From: Mark Warwick
Sent: 12 February 2018 12:18
To: David Easton
Subject: Y/92/17/OUT

Planning Officer: David Easton

Planning Application Ref: Y/92/17/OUT

Location: Land east of Drove Lane, Yapton

Tree Constraints Plan

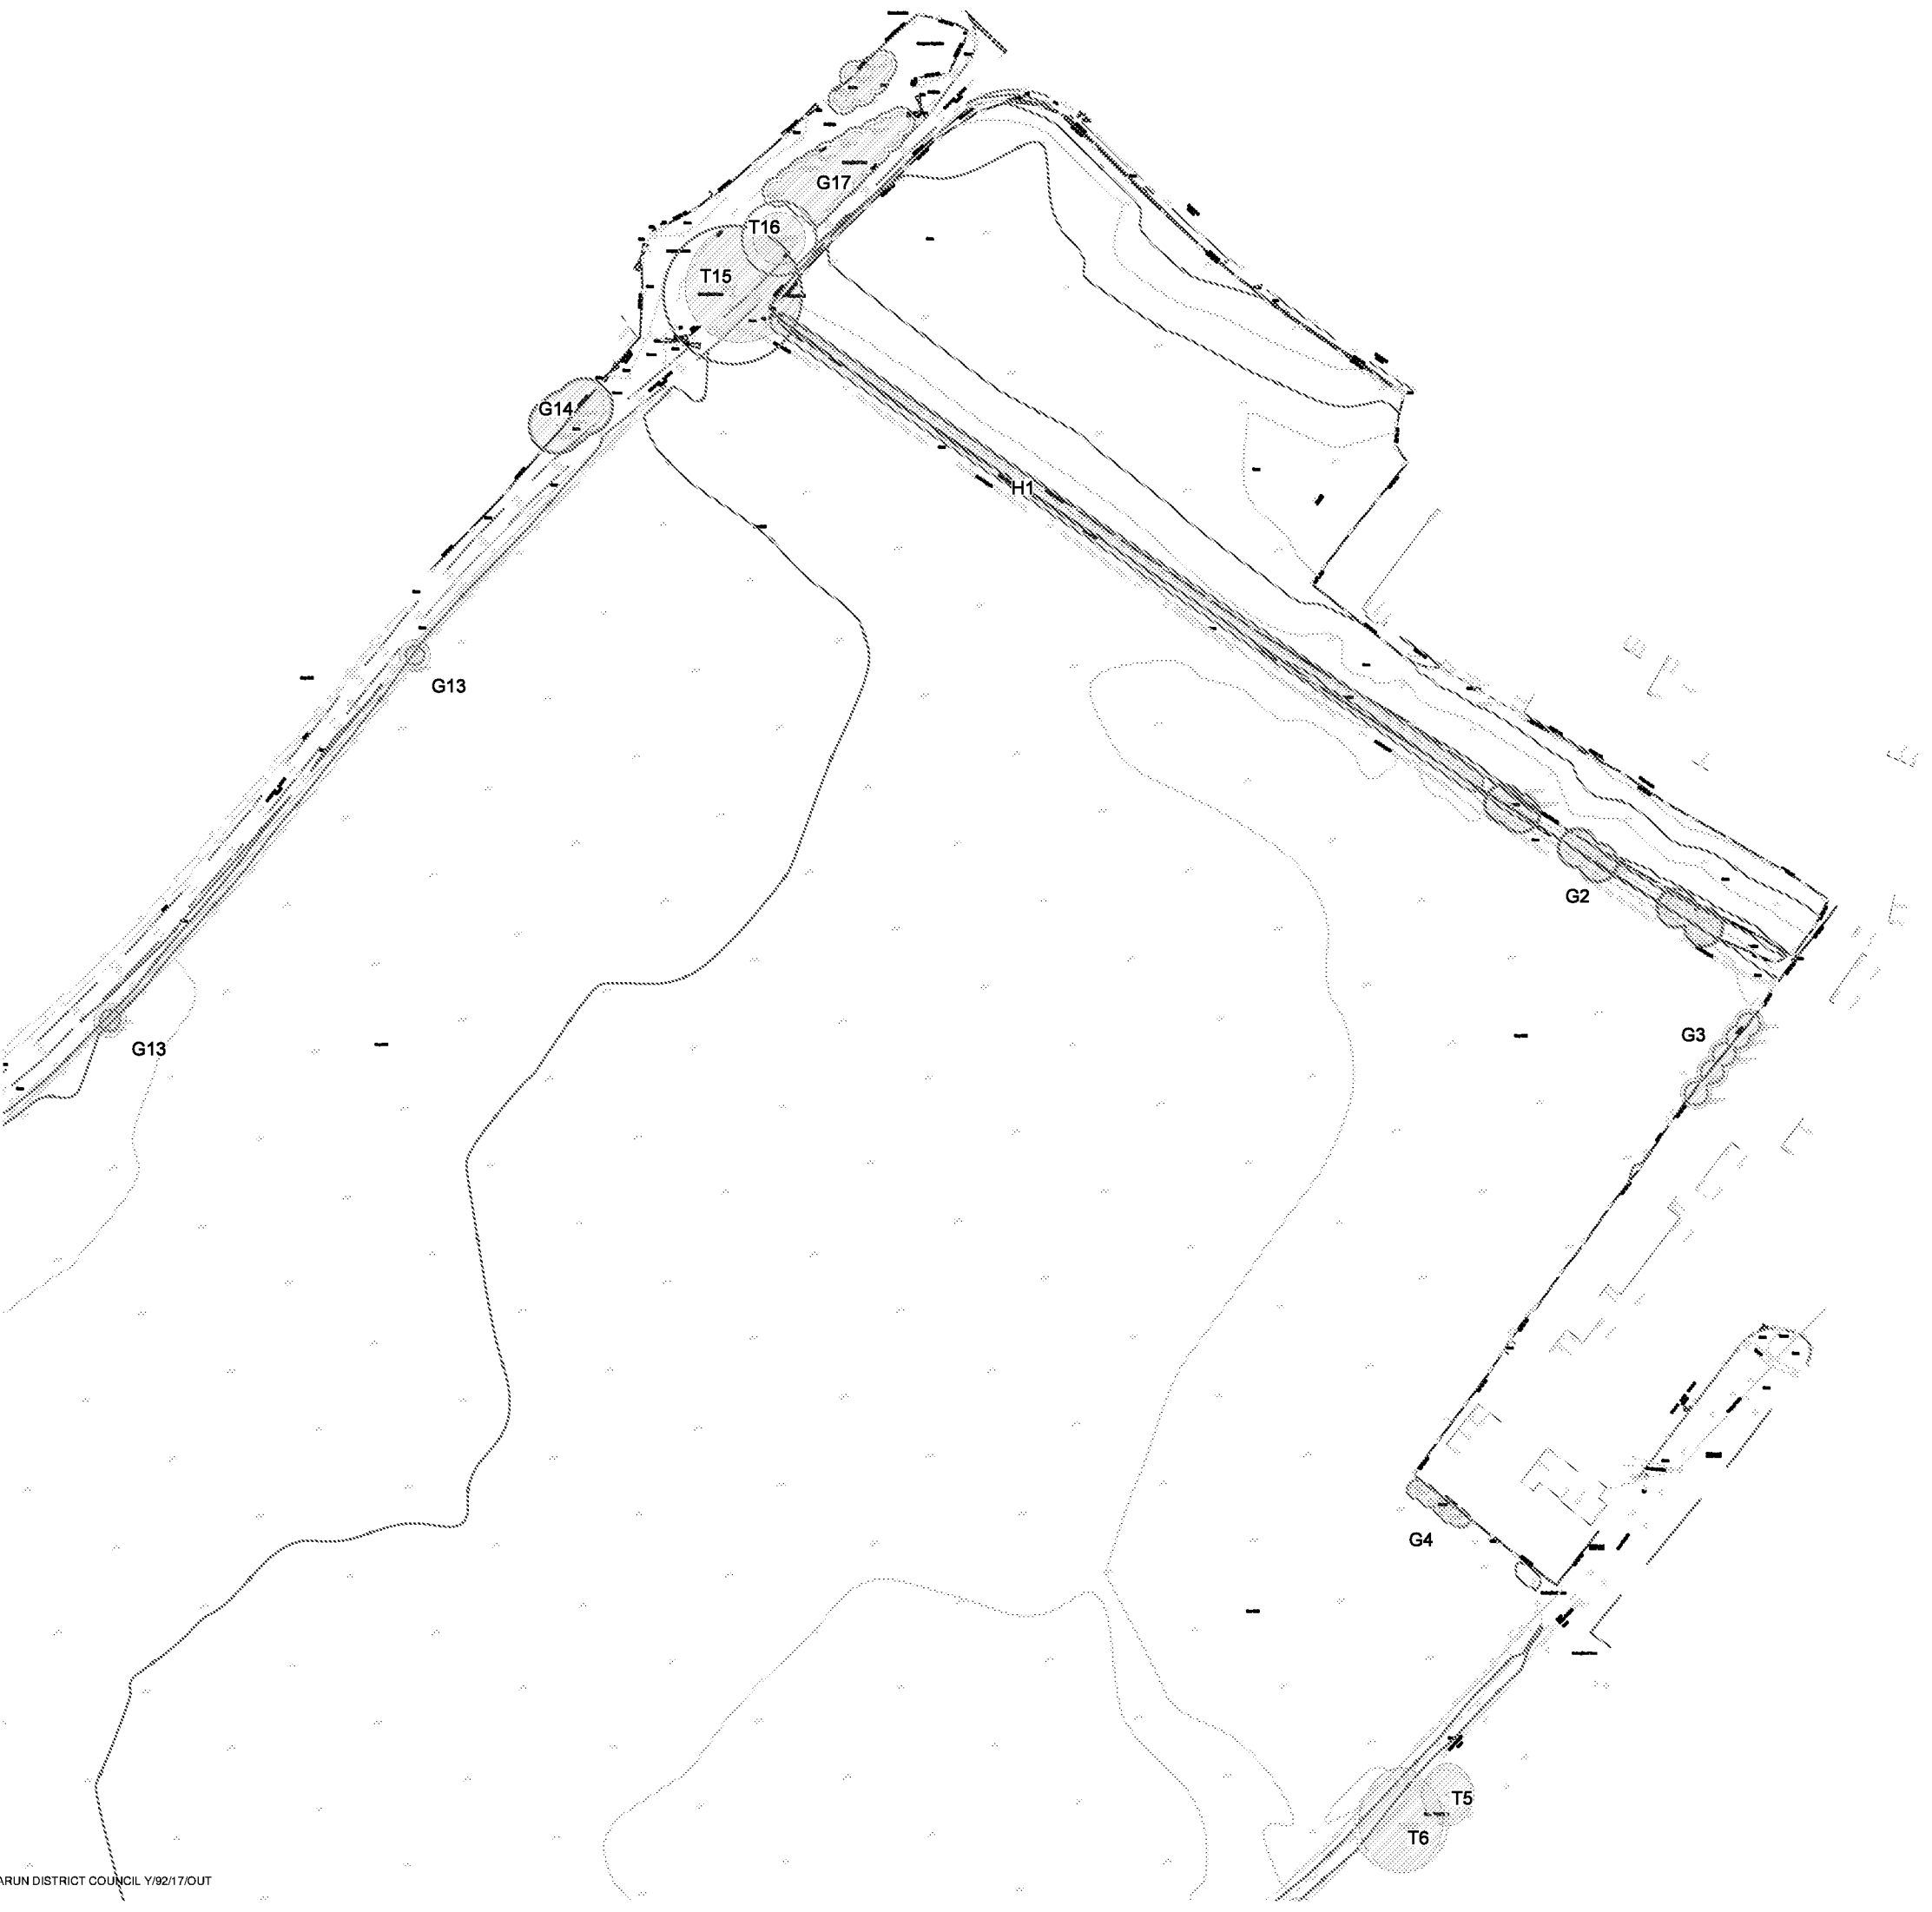
- I have referred to Illustrative Masterplan drg. 1244L.03 to assist with determining the accuracy of the Tree Constraints and Tree Retention Plans submitted by PJC with their AIA report. This allows me to gain a general understanding of how the plot layout and access routes relate to trees but is not specific enough for me to have full confidence they will be adequately respected and protected.

- I am pleased to see there is intent to retain all recorded trees for development, but I cannot be satisfied that this will be achievable until we receive a Tree Protection Plan overlaying the final proposed site design layout, with supporting Arboricultural Method Statement where RPA incursion is anticipated - which I would expect to see submitted with a subsequent full planning application.
